Your Ref: TR010025

Date: 25 September 2019

A303 (Stonehenge) Amesbury to Berwick Down scheme
Environment Agency – Written Representations – Deadline 9

Written Representations

Figure 4.1: Tunnel Drainage Schematic

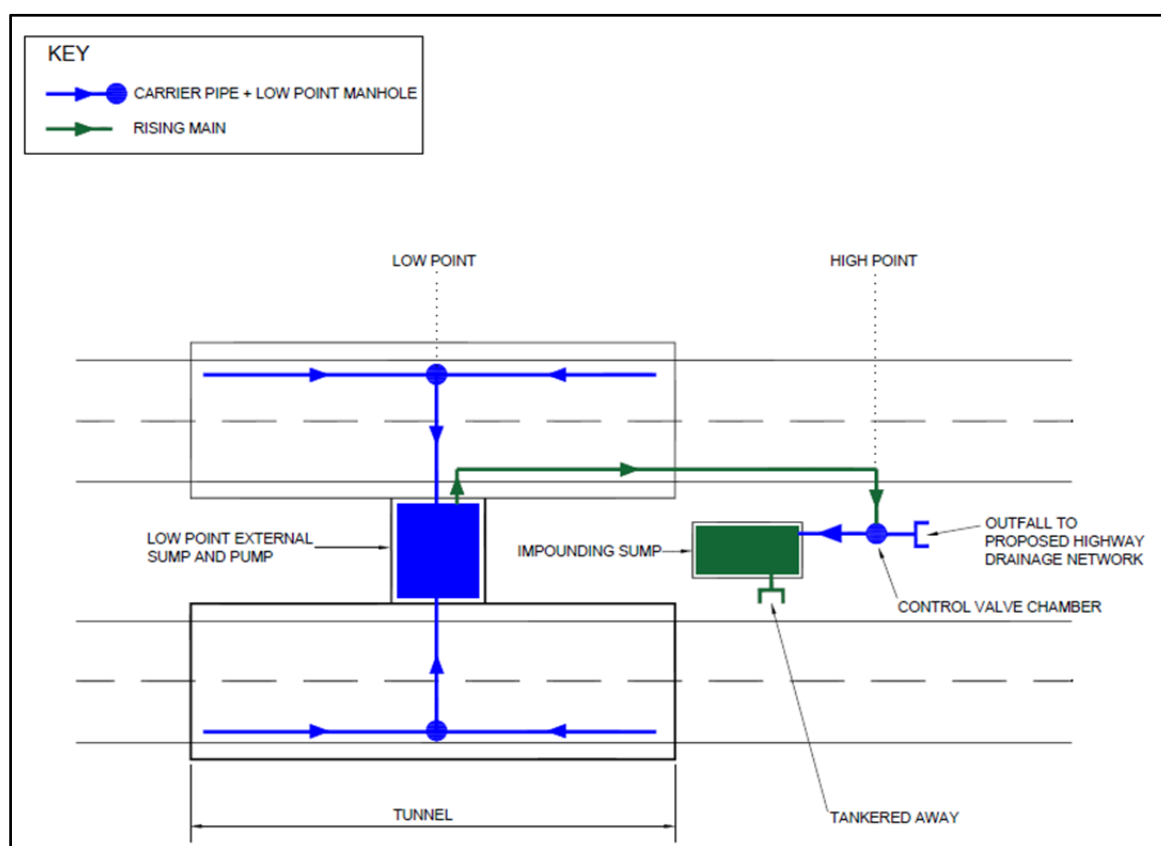
2.6.1 Tunnel drainage - We maintain our position that the valve diverting runoff from within the tunnel to an impounding sump rather than discharge to the environment should be automatic so it is operated when any signage is operated to indicate there is an accident, maintenance work or incidents within the tunnel. This will help to ensure that the risk of any spillage or release of any contaminants are discharged appropriately, minimising the risk to the environment. It will also reduce the workload of any control room, during such circumstances, and not rely on human activation by either on-site controls or remotely. We consider that it would provide the most robust assurance of timely operation if the valve were linked to warning signs of incident or maintenance within the tunnel.

2.6.2 We consider that if linked to signage, there will be low occurrence of inappropriate activation of the diverter valve as certain checks would have been made prior to or following their illumination. The automation simply removes the physical burden and risk of error/delay of an operative having to activate a valve separately to activating signage and dealing with a great number of other issues should an incident occur within the tunnel.

2.6.3 Our position on this matter is unlikely to change and although we recognise that consultation under Requirement 10 of the DCO will provide an opportunity to make this recommendation at the detailed design stage, we feel that incorporating this design principle into the DCO or OEMP would provide greater clarity to potential contractors
